Lake House – Corrections Response Letter

Building Plan Reviewer: **City of Mercer Island**

Response to: 2012-200 Lorenzini Remodel 2R
Dated: June 17, 2021
Permit #: 2012-200
Project address: 3310 97th Ave SE
Mercer Island, WA 98040

Re: *Lorenzini Remodel (Lake House) at 3310 97th Ave SE Permit No. 2012-200*

SHEET NO.
S2.2

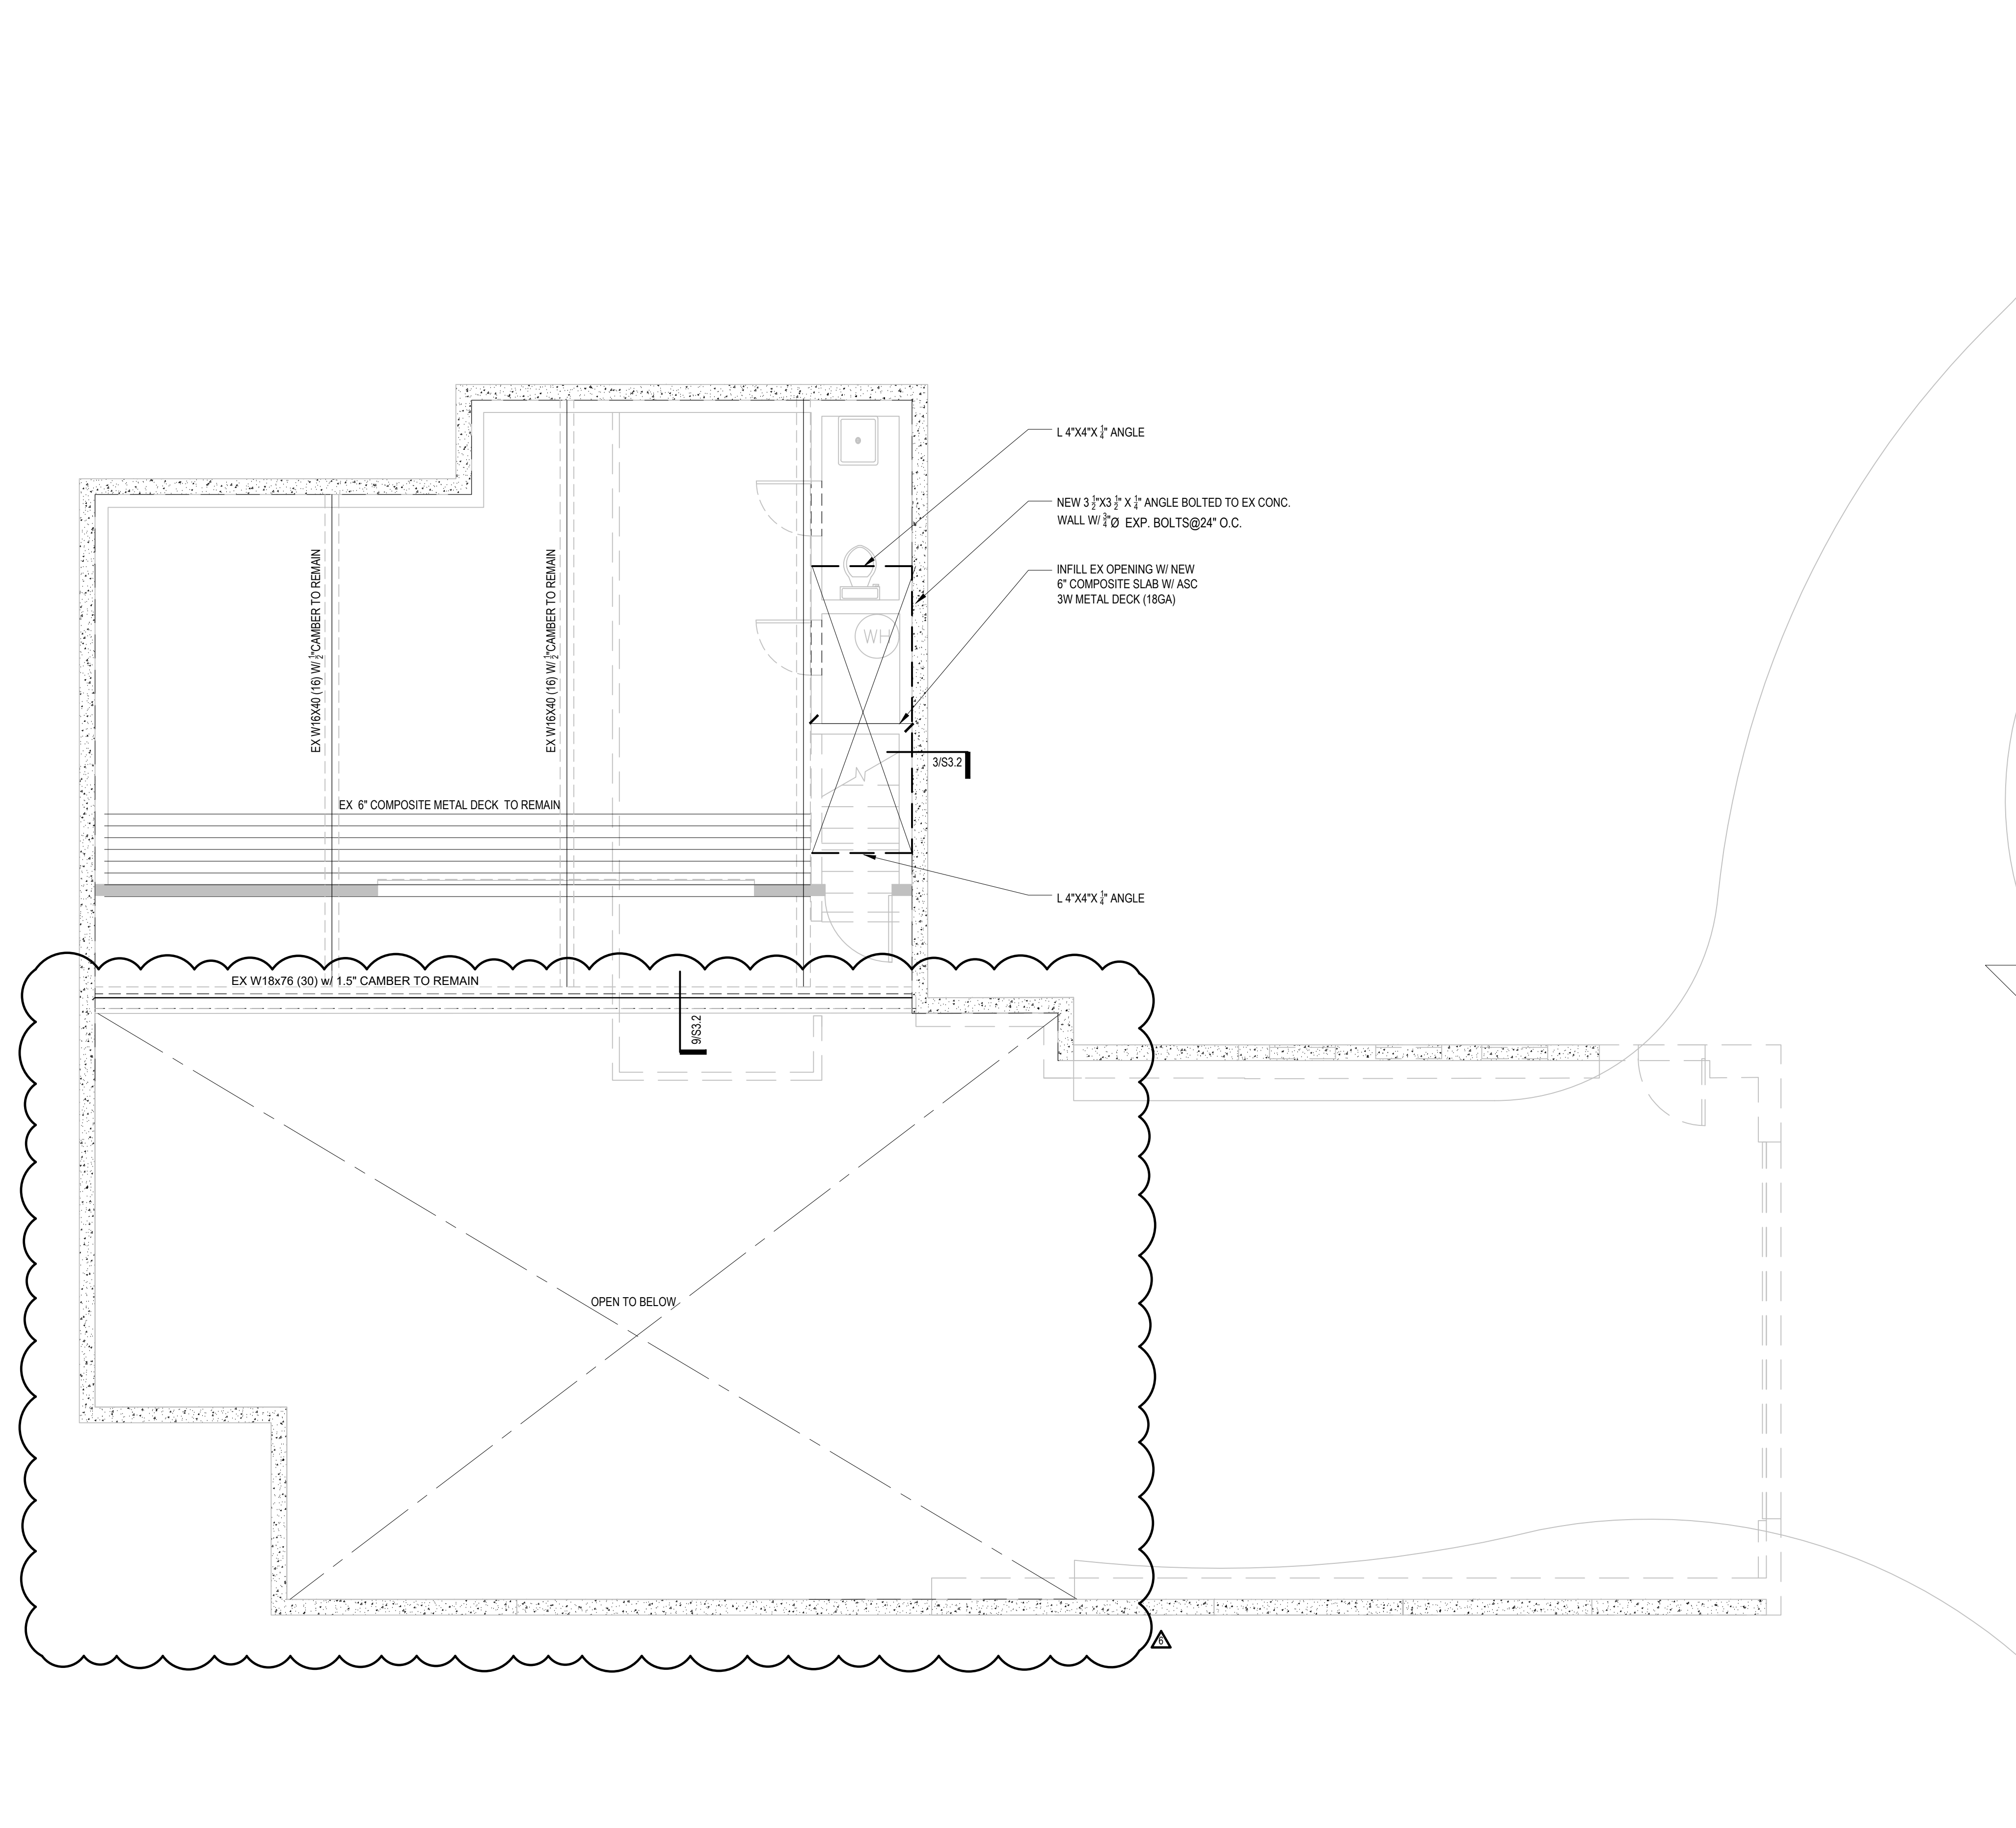
2. The Roof Plan, Sheet S2.2, cuts Details 16, 17, & 25/S3.2 at the chimney. There is no Detail 16. Also, we do not find Detail 21/S3.2 cut in plan. Please clarify.
The detail showing the connection of the 6x6 roof purlins to the CMU chimney has been corrected to box 16 on S3.2

4. Clarify the location of required straps providing seismic anchorage of the masonry chimney as required per IRC R1001.4.1. We find Detail 17/S3.2 cut on the Roof Framing Plan; however, show each location of the strap and connection to the roof framing members as indicated per code. The same clarification is needed at the floor.
Specific callouts for the PA22 and PA28 floor and roof strap ties have been added to the plans as well as being shown in details 17 and 22/S3.2

13. For resistance to seismic loads, wood-frame diaphragm in open-front structures must meet the requirement in SDPWS 4.2.5.2. Evaluate, by providing calculations, the impacts at the open front condition along Grid 1 at the Garage considering these requirements. Please cut a detail on the Roof Framing Plan along Grid 2.5 above the Garage.

- c. Cut a detail on the Roof Framing Plan showing shear flow connection into the shear wall below that is perpendicular to the roof trusses.

20. Cut a detail on the Roof Framing Plan showing shear flow connection into the Type F shear wall below that is perpendicular to the roof trusses.

23. Detail 7/S4.1 is cut at the roof, Sheet S2.2, above the Type H shear wall. It does not appear this is the correct detail.

Detail 21/S4.2 has been added to the plans and referenced on S2.2

Detail 21/S4.2 has been cut at Shear wall F on S2.2

The detail has been corrected to 7/S4.2
